**Marine
Management
Organisation**

Mr Richard Cram,
Able UK Limited
(By email only)

Our references: SAM/2020/00052
DCO/2013/00020

**SAMPLE PLAN ADVICE FOR SAM/2020/00052 ABLE MARINE ENERGY PARK –
UPDATED ADVICE**

Proposed Sample Site Positions 2020, Able Marine Energy Park

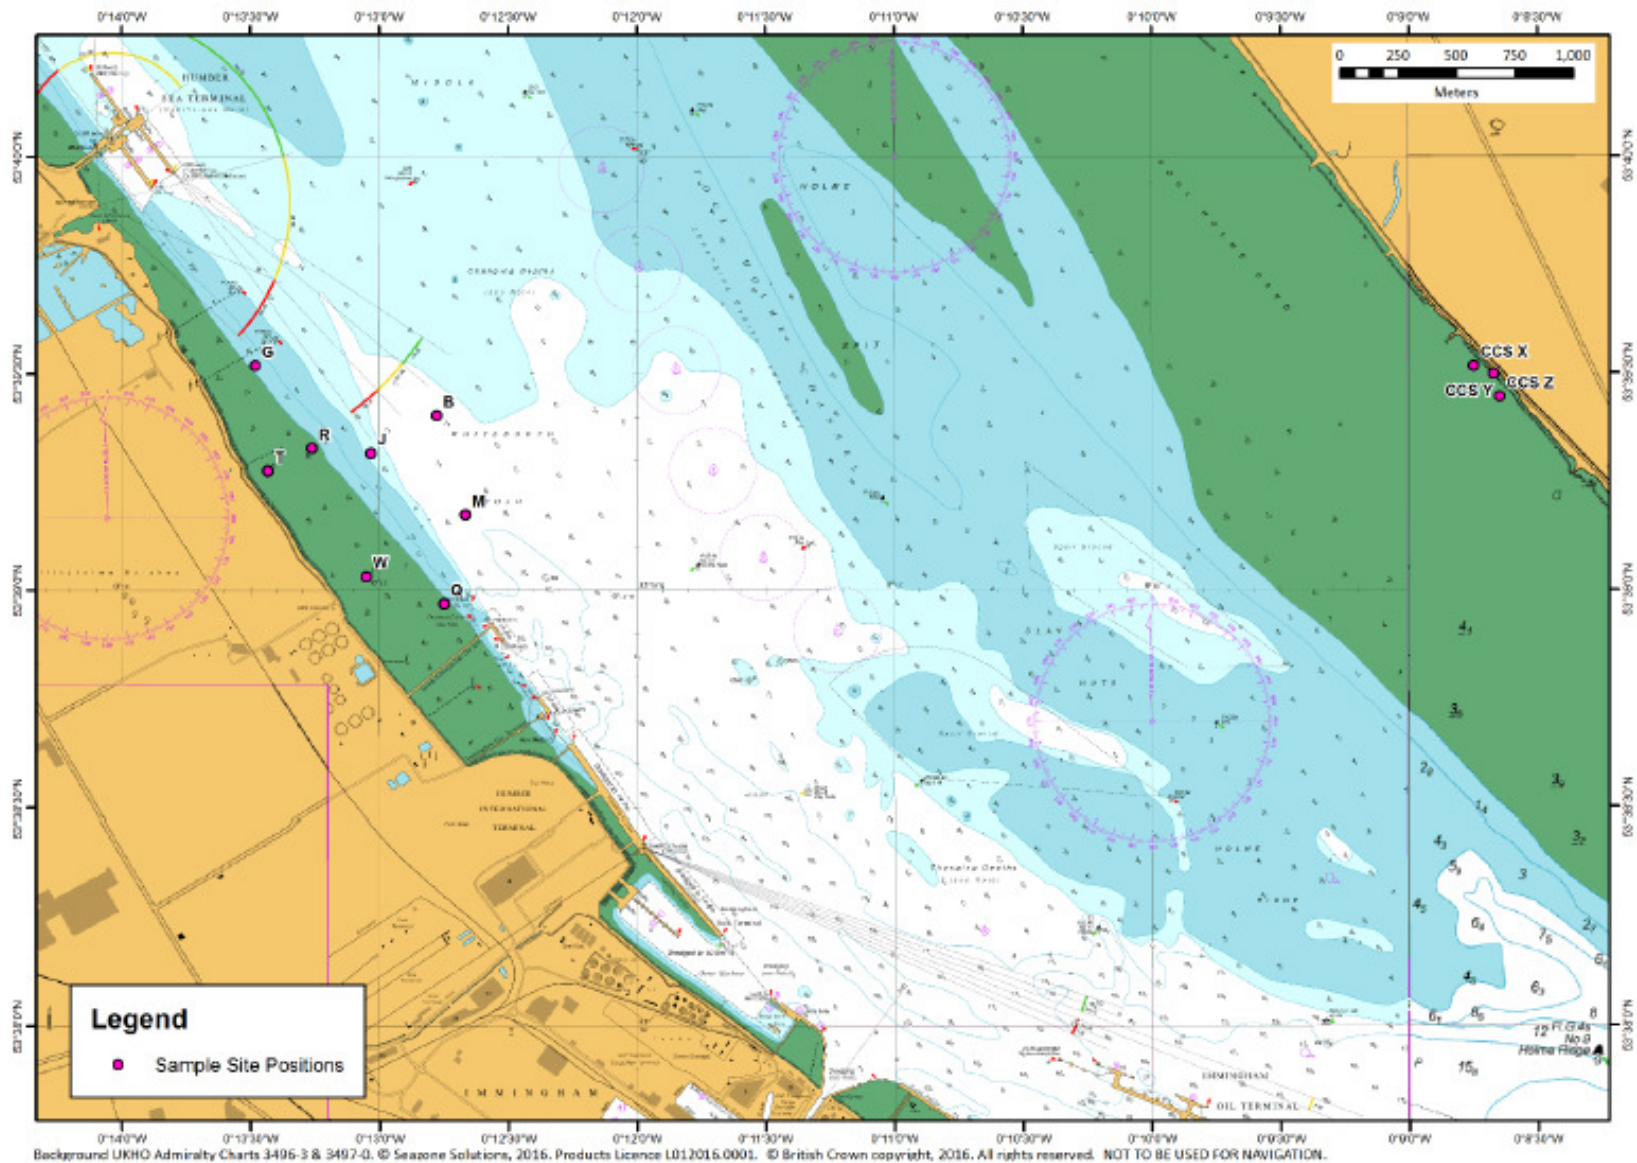
Comments:
Stations should be collected based on the applicant's provided sample map
